**7 Diamond Pass, Peaks Island - Permit #2017-01012**

**From:** Ann Machado [mailto:[amachado@portlandmaine.gov](mailto:amachado@portlandmaine.gov)]  
**Sent:** Thursday, July 13, 2017 3:30 PM  
**To:** Silas Canavan <[silas@walsh-eng.com](mailto:silas@walsh-eng.com)>  
**Subject:** 7 Diamond Pass, Peaks Island - Permit #2017-01012

I tried to call but you were in a meeting. I have completed my initial review and I need more information before I can sign off for zoning. Here is the list:

Drawing:
GUEST SPACE - PLAN AND EXTERIOR ELEVATIONS
Date:
June 15, 2017

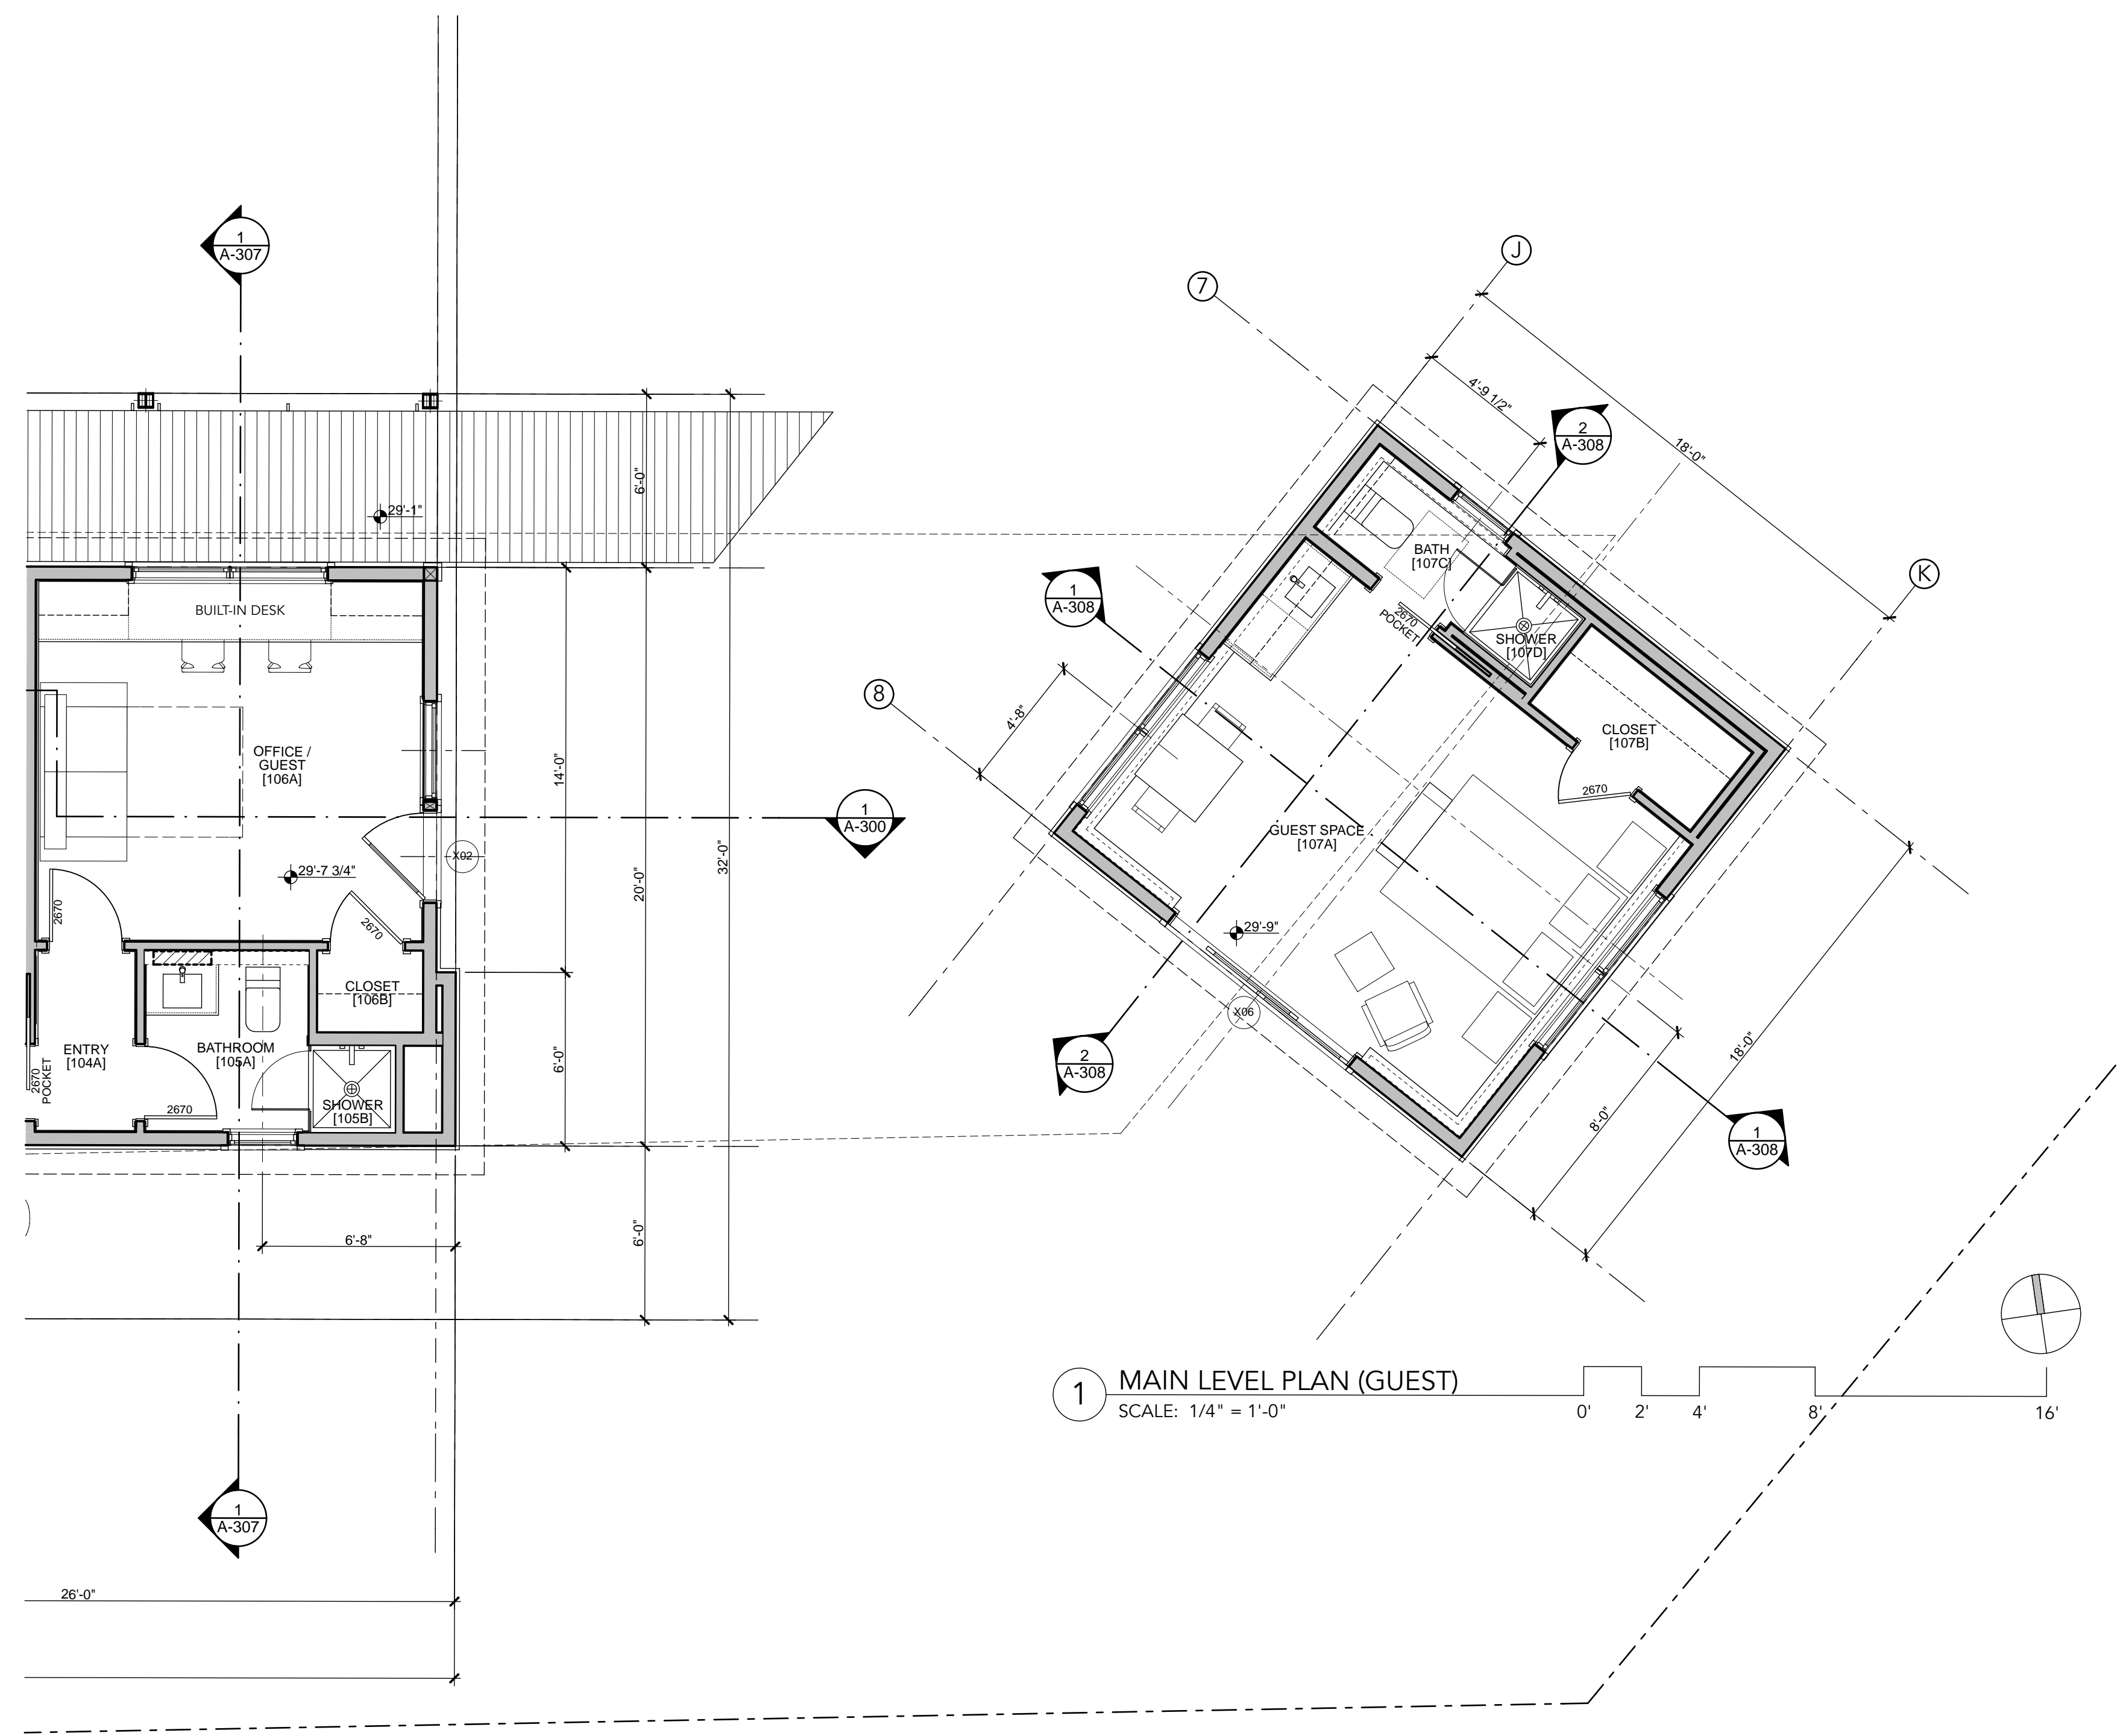
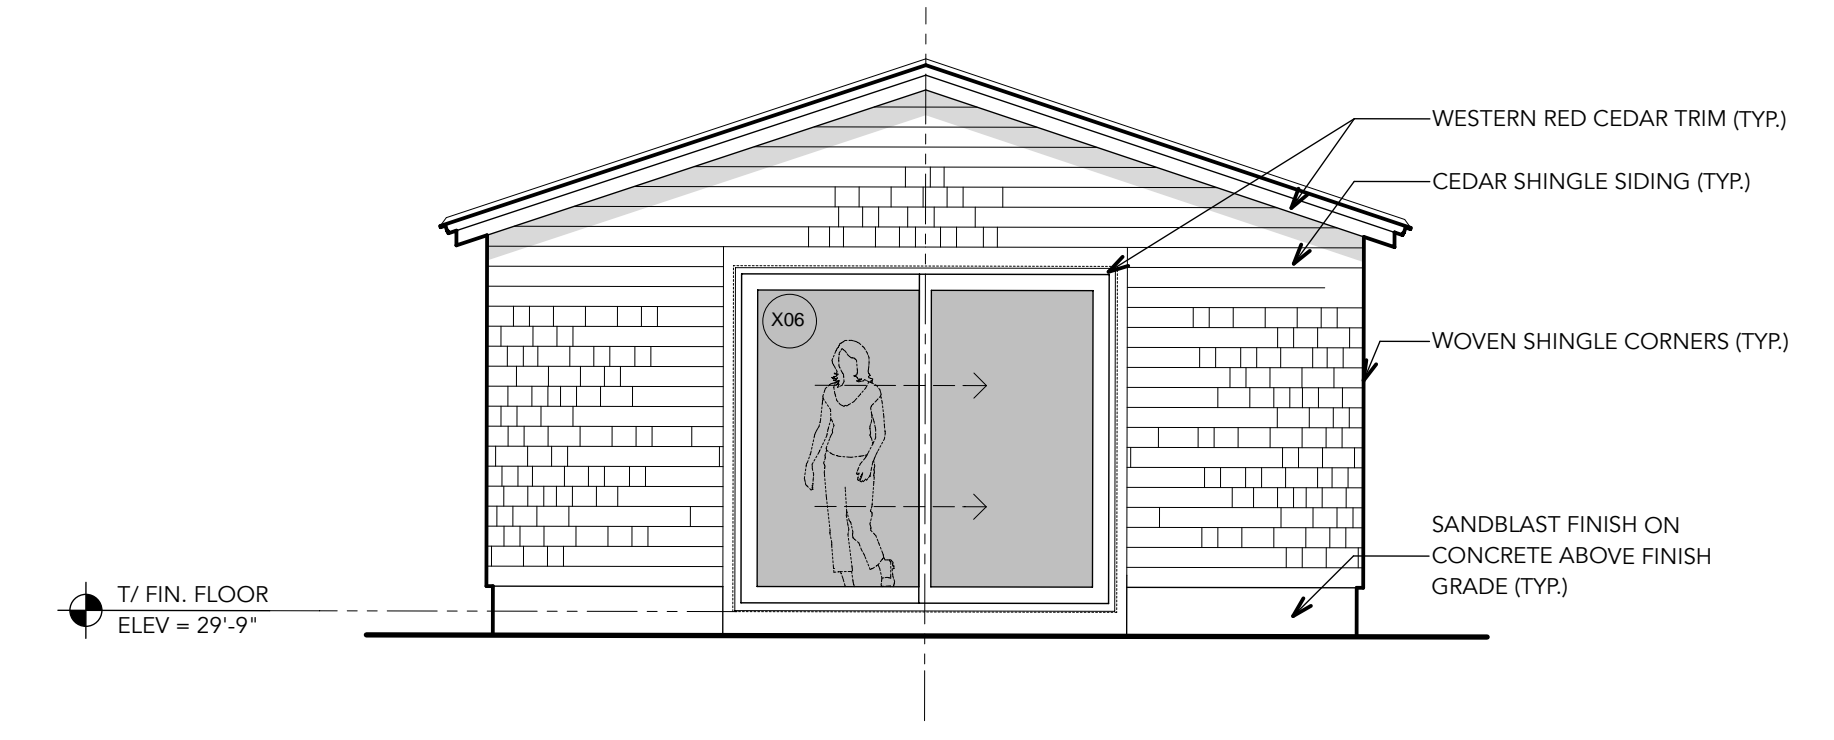
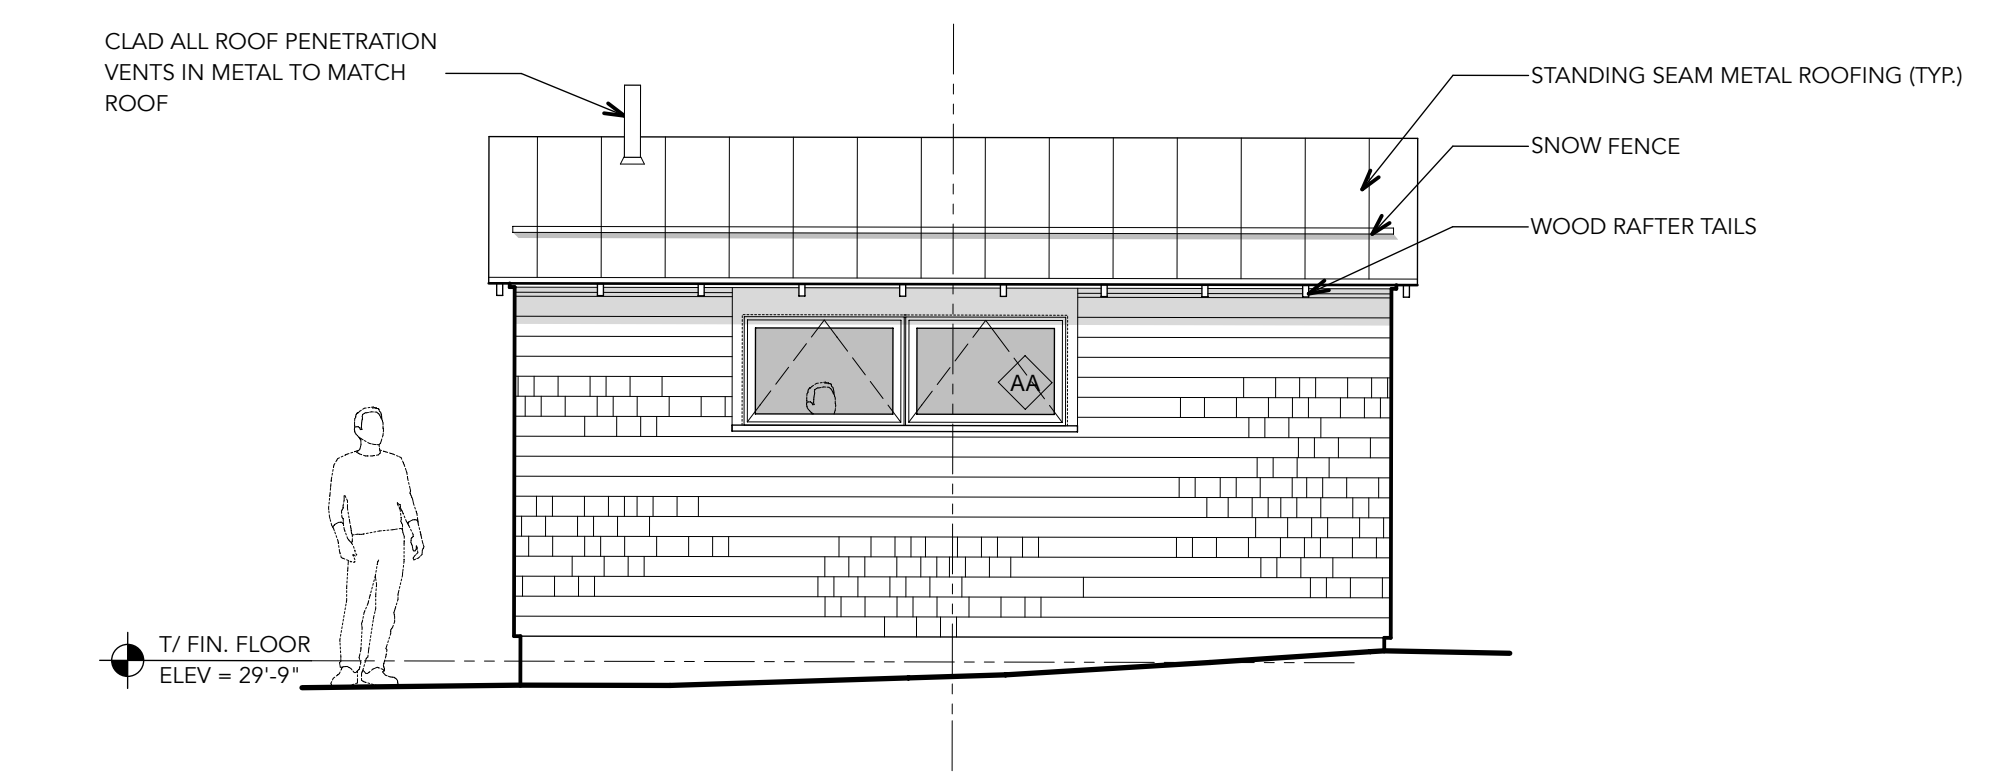
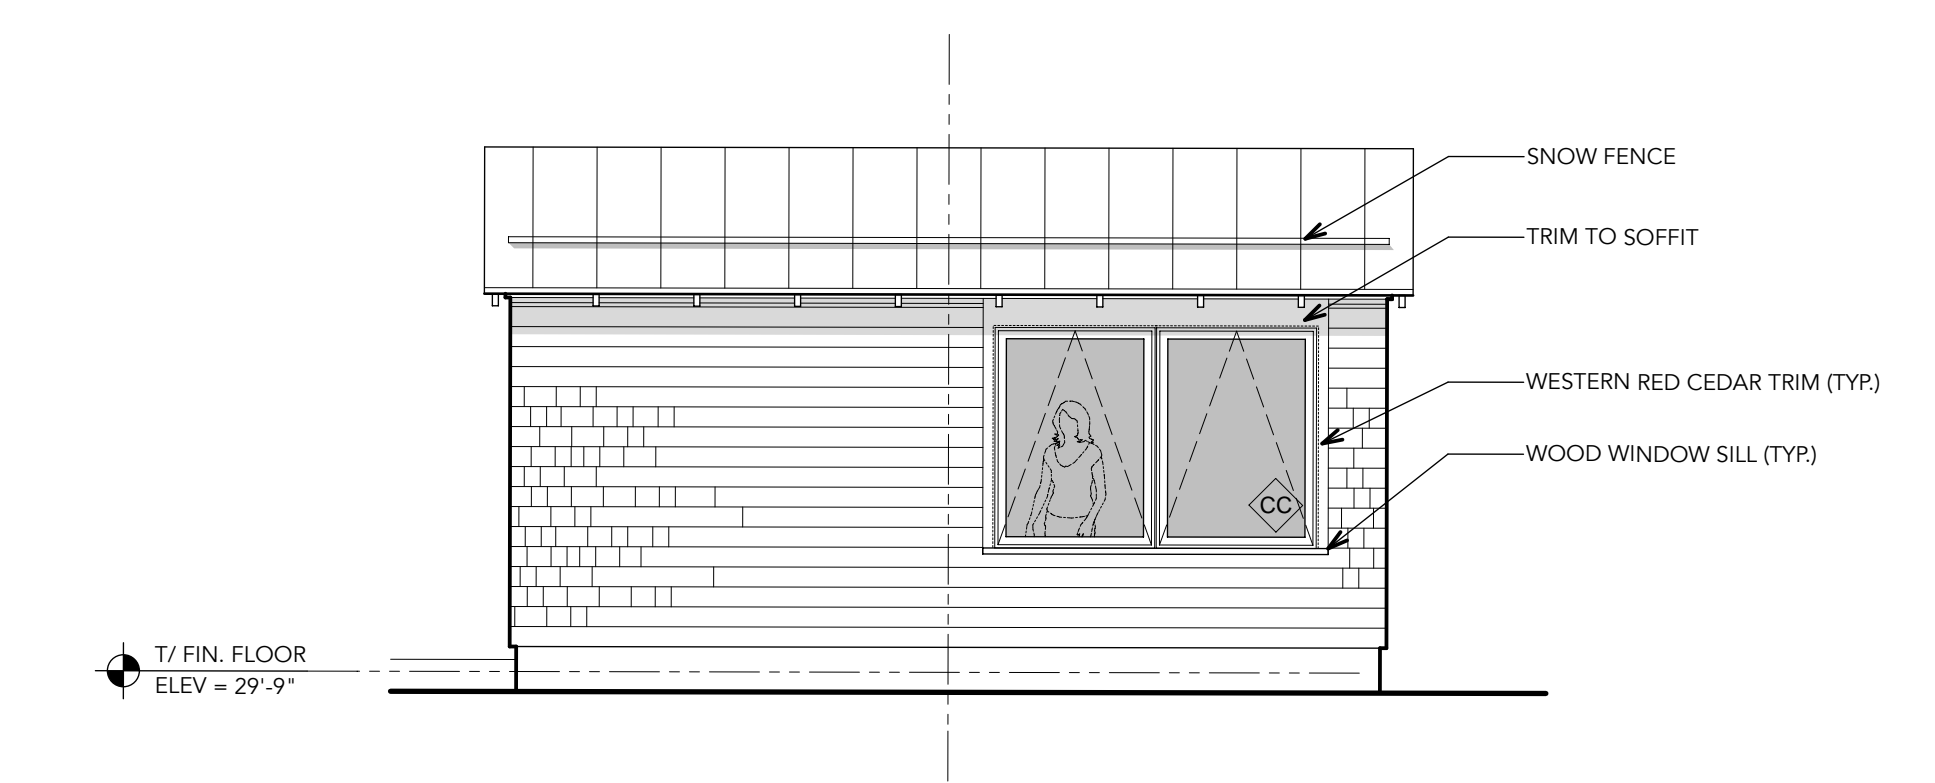
6. Within the guest house, there can only be a bathroom sink and no kitchen equipment.

I don't believe there is any kitchen equipment proposed in the guest house. There is one sink, it just happens to be separated from the toilet/shower. Is this a problem?
